Planning Officer: Mr Z Denton

Planning Application Ref: EP/75/19/PL

Location: Seahaven (Land West of Ash Hollow), Seafield Road, East Preston, BN16 1NA

Description of works: 1no. new dwelling (re-submission of approved application reference EP/105/16/PL).

Drawing Title: Tree Protection Plan

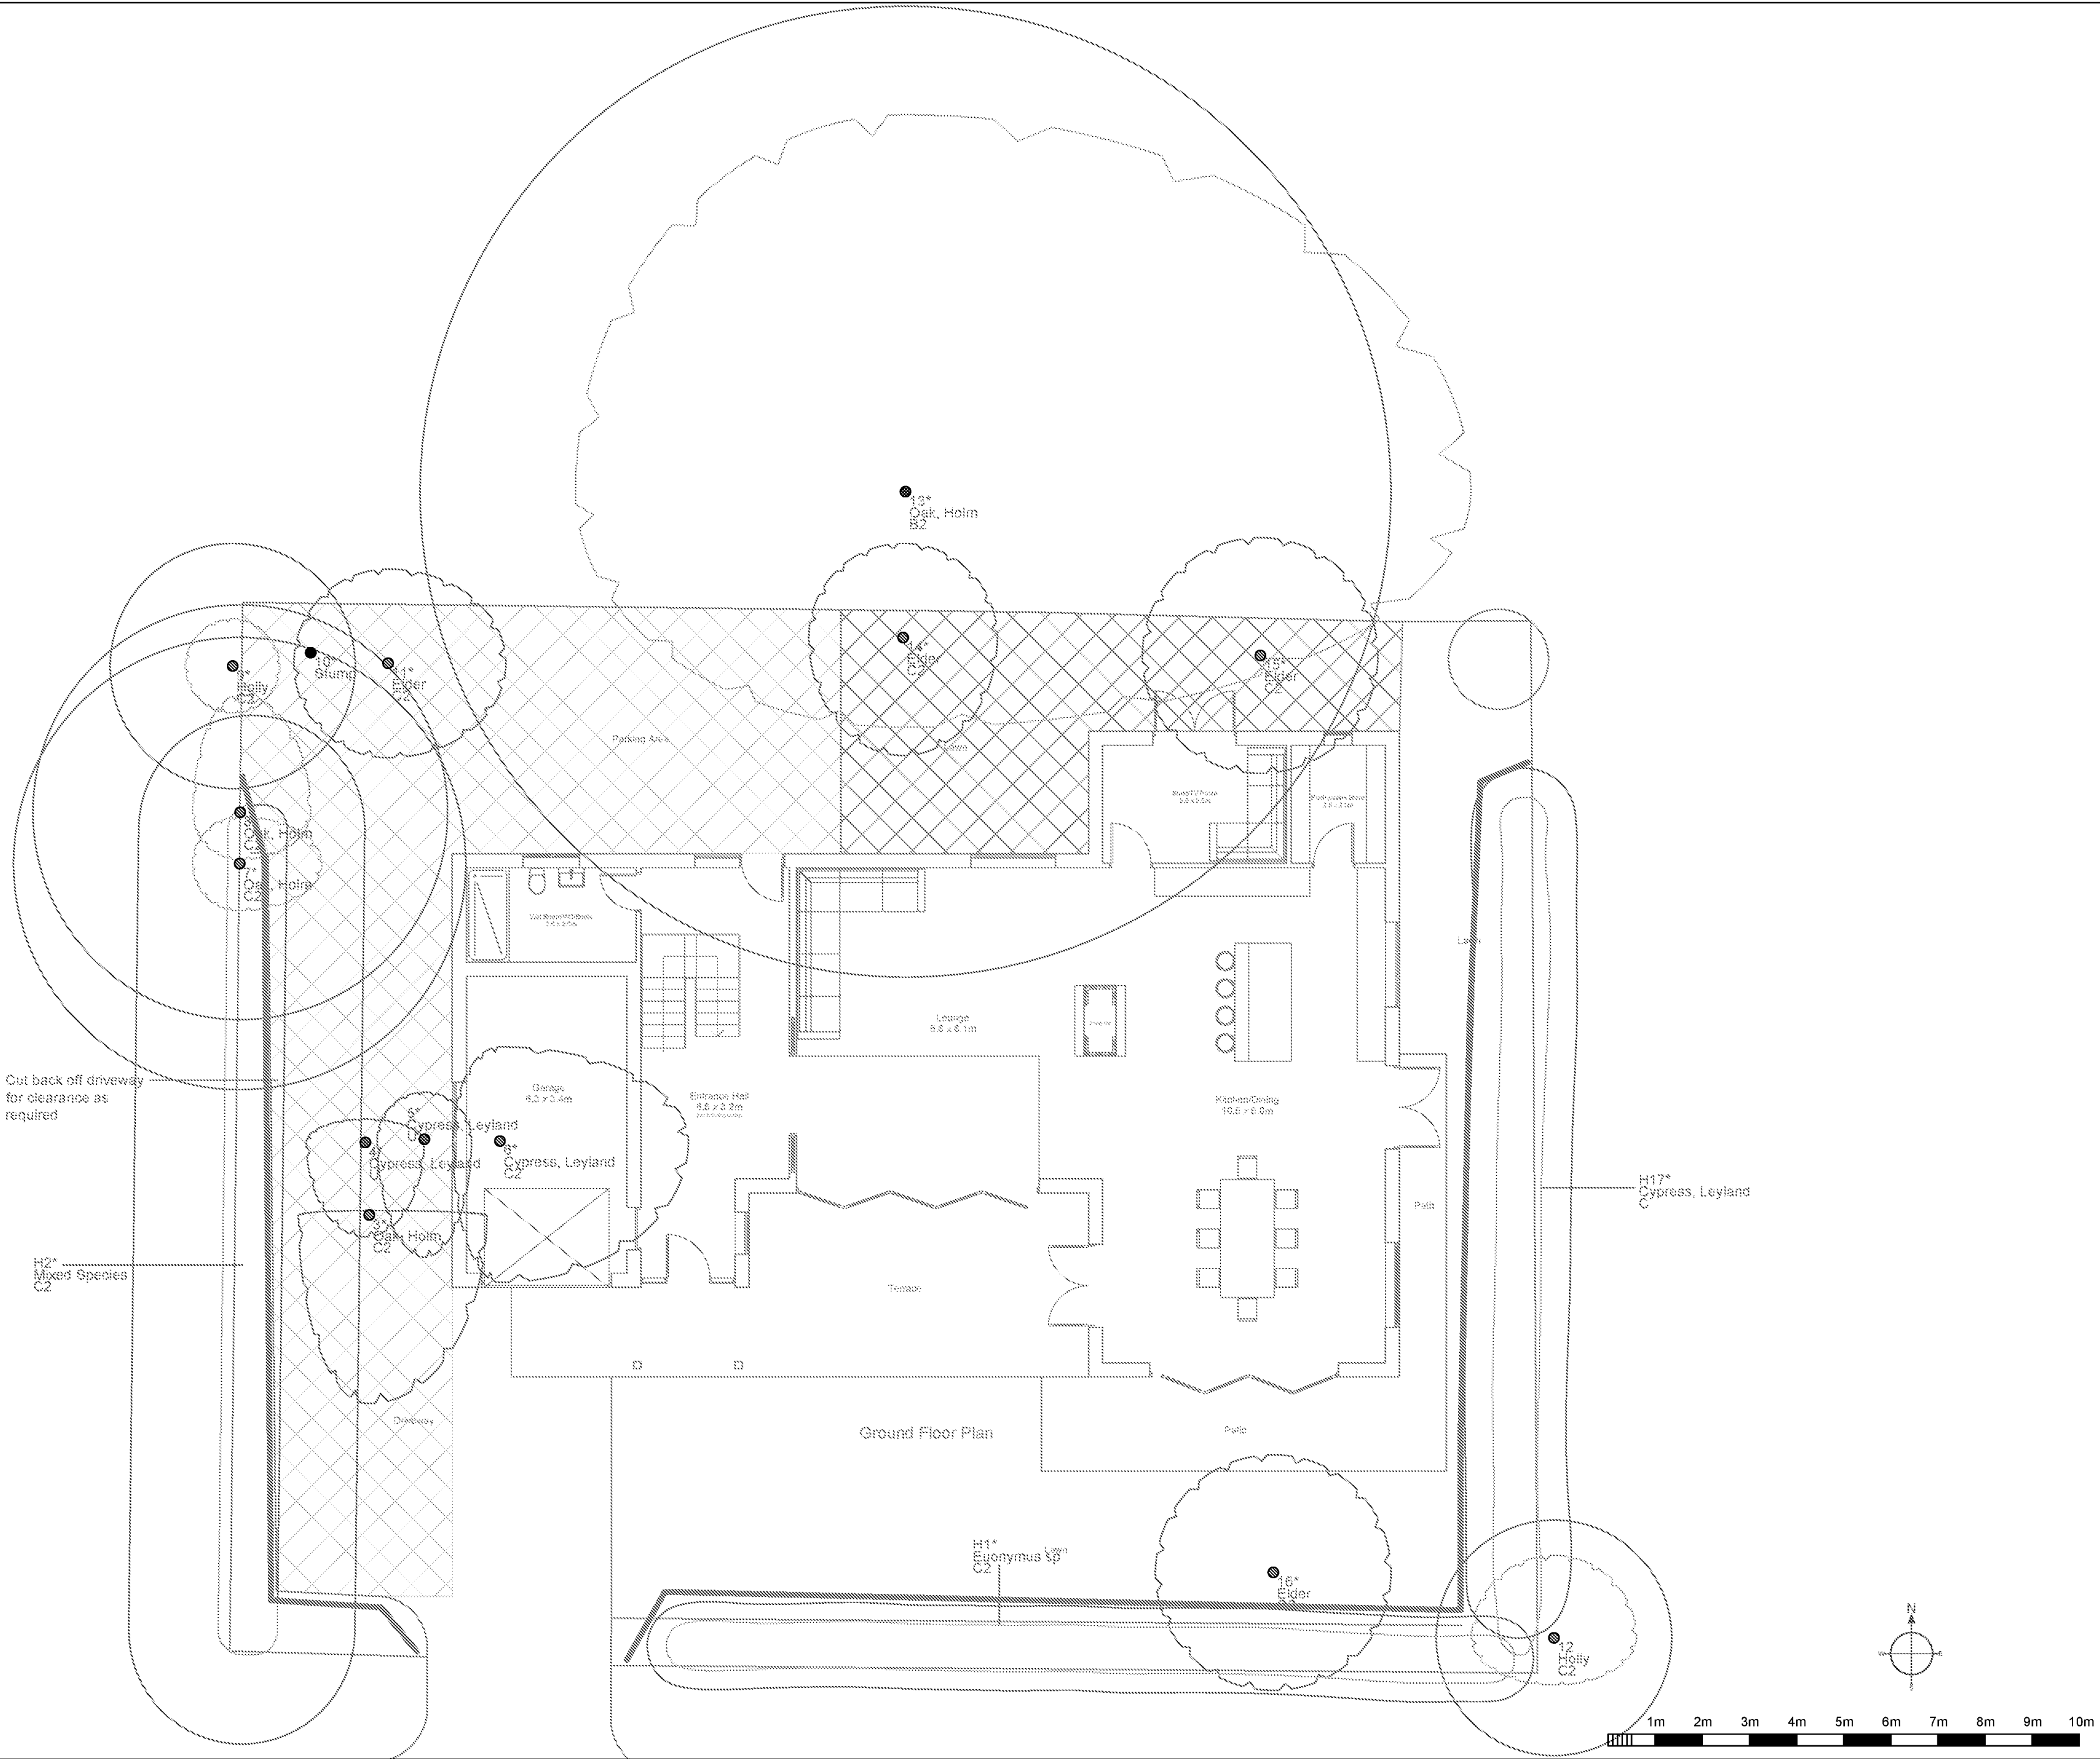
- The proposed 'No-dig' solution for driveway and parking across the site is welcome and an essential element of the tree protection measures required at this site; although it appears to be excessive along the site's west boundary. I could support a revised (reduced area) 'No-dig' proposal were it to terminate at the southern periphery of T7's RPA. The applicant's engineer will need to consider any potential impact on ground level changes.

- Ordinarily it would be essential that all of T13's RPA which exists outside of the proposed building footprint; either reside within a fenced-off construction exclusion zone (CEZ) or enjoy the same ground protection prescribed for its easterly aspects. Within this set of proposals, the AMS refers to the 'No-dig' areas being implemented early in the development, so we can assume that the exposed westerly aspects of T13's RPA will not be interfered with - providing those works are executed correctly and under supervision.

- This proposal will have an impact on the one tree of moderate value overlapping the site, although it is within acceptable tolerances of RPA intrusion. It is therefore essential that the RPA of T13 which exists outside of the building footprint is suitably protected and I am satisfied that this latest set of arboricultural proposals aims to achieve that.
- Adequate on-site supervision and reporting during tree-critical phases of the development will be necessary to ensure compliance with the approved arboricultural reports and plans.

- All activity at the site is to be carried out in strict accordance with: - **Arboricultural Impact Assessment & Method Statement, ref: jwmb/rpt1/seahaven/AIAAMS, 8th August 2019.**

- Before the site is occupied or any machinery is introduced to the site or demolition work or construction work or alterations to existing ground levels takes place a **PRE-COMMENCEMENT Site Meeting** is to take place between the Planning Authority's Tree Officer and the Arboricultural Expert representing the site owner(s) – at this meeting all protective fencing and ground protection measures will be inspected to verify they are 'Fit for Purpose' as required under British Standard 5837:2012 and have been erected and positioned exactly as shown on the **Tree Protection Plan (Appendix A of the AIA/AMS), August 2019.**
